DRB Application No.: 04DRB-00609 (SBP)
Project Name: JOURNAL CENTER PHASE 2, UNIT 1
Agent: Crawford-Slagle Business Park LLC

11. **Project # 1003398**
04DRB-00609 Minor-SiteDev Plan
BldPermit
04DRB-00611 Minor-Prelim&Final Plat
Approval

**CITY OF ALBUQUERQUE
PLANNING DEPARTMENT
Development Review Board
April 28, 2004
Comments**

Re: Lots 15 & 16 at Journal Center II/SPBP/minor plat

**Site Plan**  
1" = 20'-0"

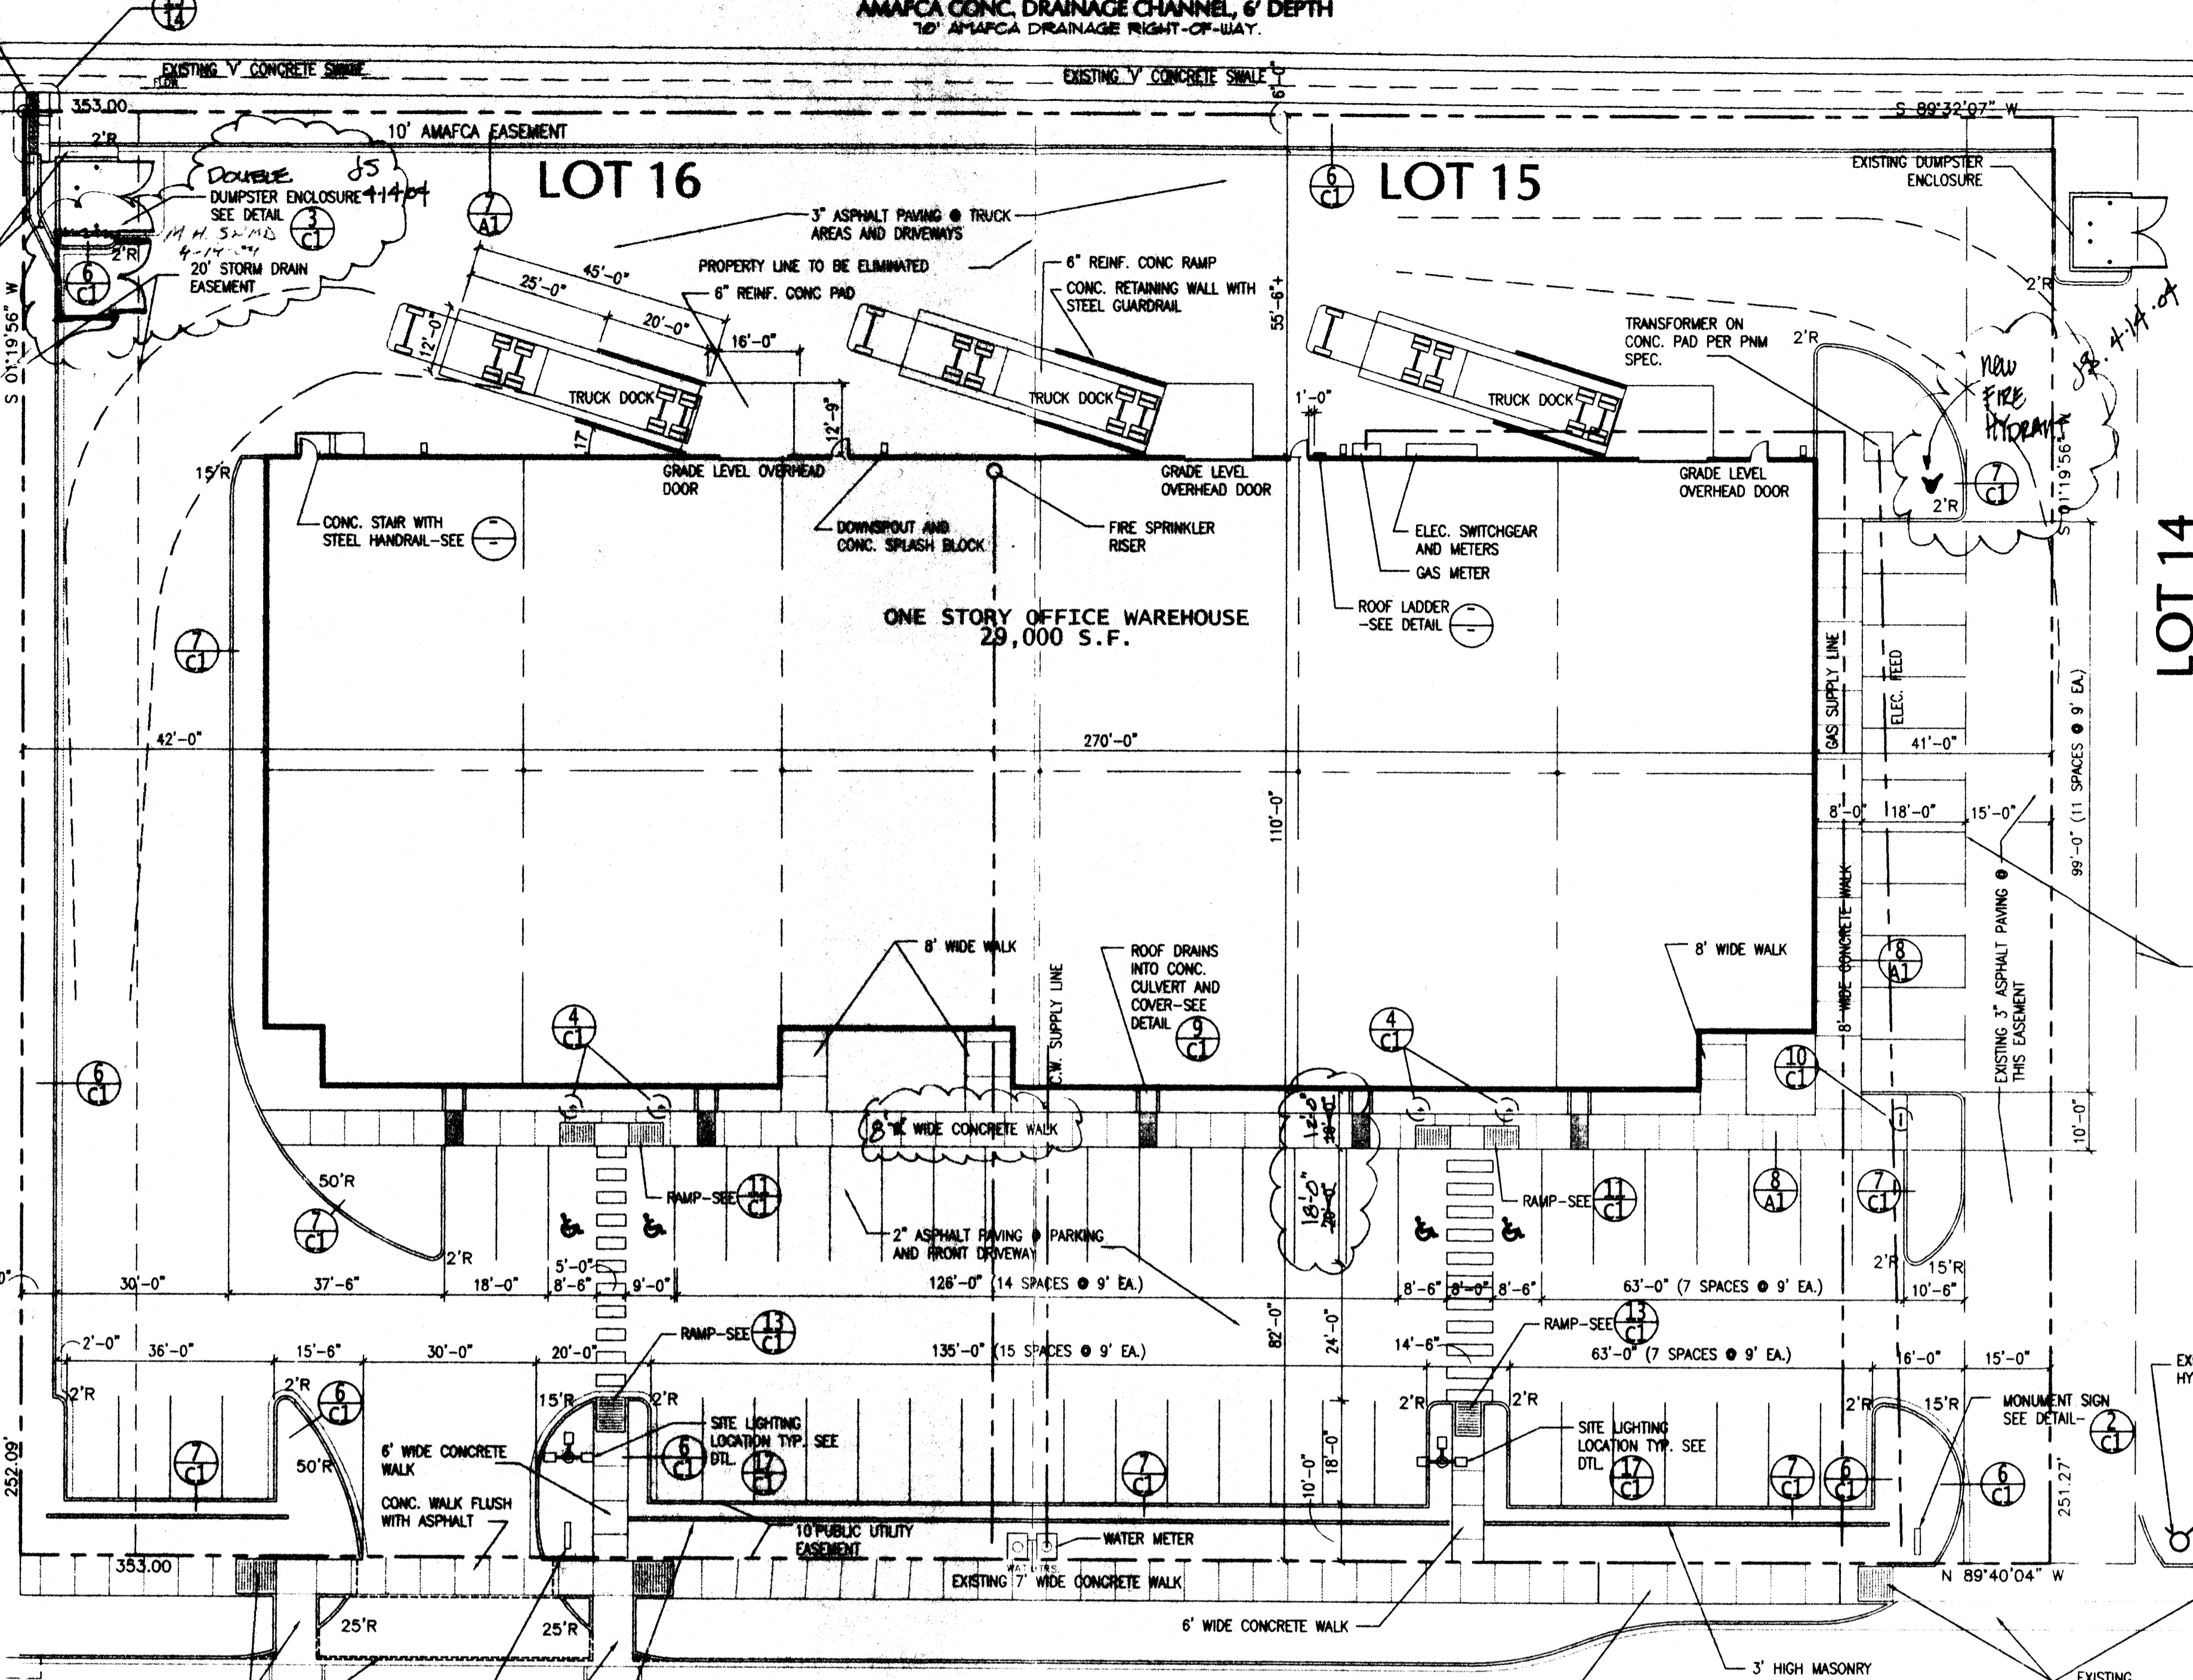
- Site plan sheet should be titled "Site Development Plan for Building Permit".
- The current signature block should appear on the site plan sheet.
- The sheets should be consecutively numbered. All old numbers should be removed.
- Section 14-16-3-9 of the Zoning Code allows only a 20 foot maximum height for light poles on sites less than 5 acres.
- Landscape Plan. The bar scale & north arrow are missing. The water usage (H,M,L) symbol should be placed beside each plant listed.
- Elevations Sheet. The bar scale is missing. Overall width of building is missing.

# PLAT OF LOT 15-A JOURNAL CENTER PHASE 2, UNIT 1

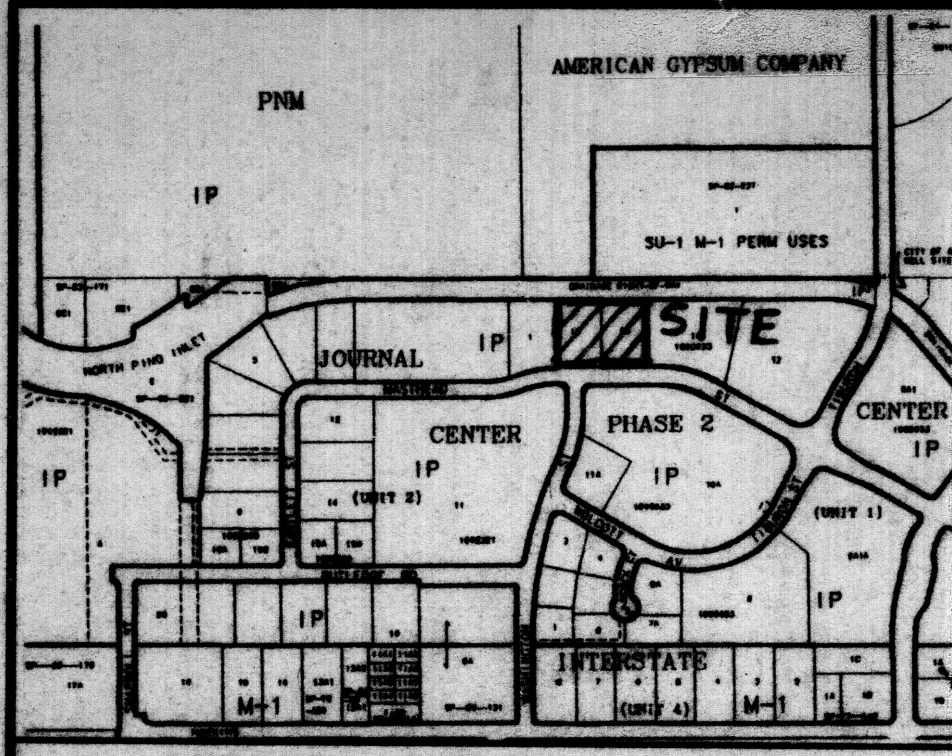
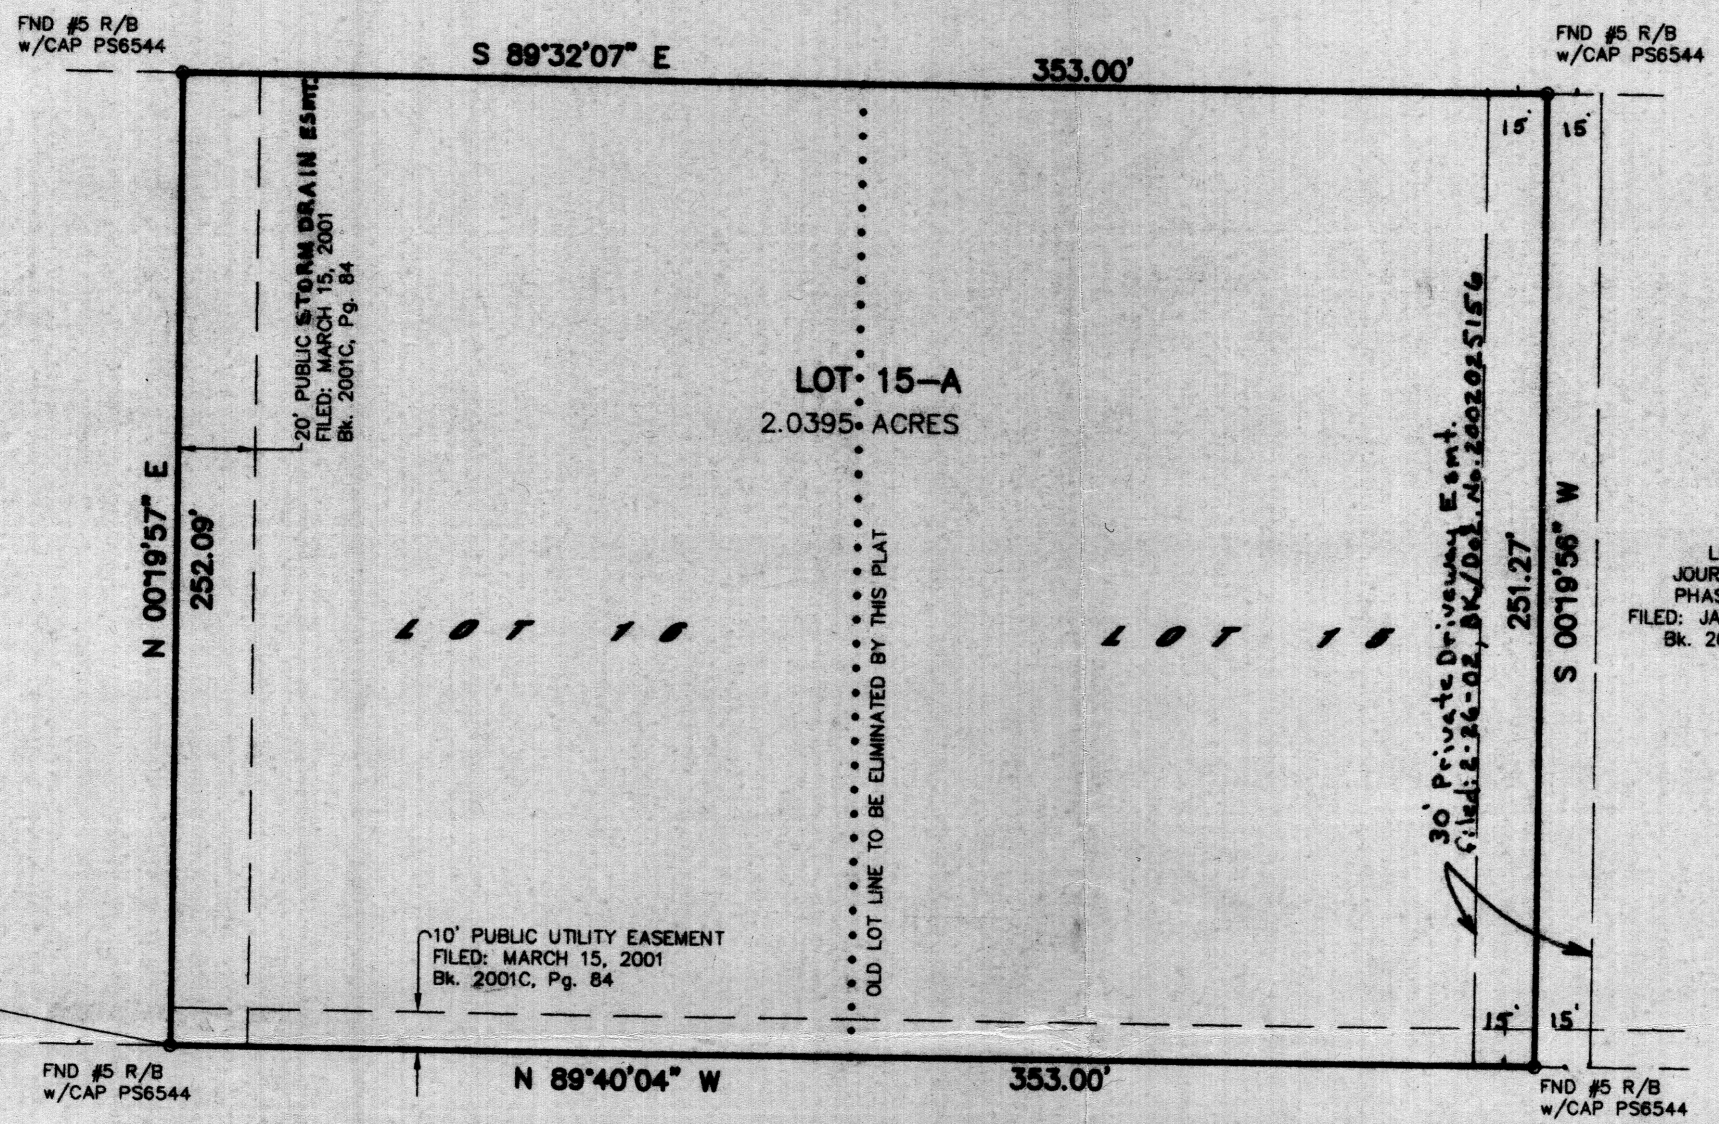
CITY ENGINEER / AMAFCA: correct SD esmt call out > Bub 5/20/04
add access esmt
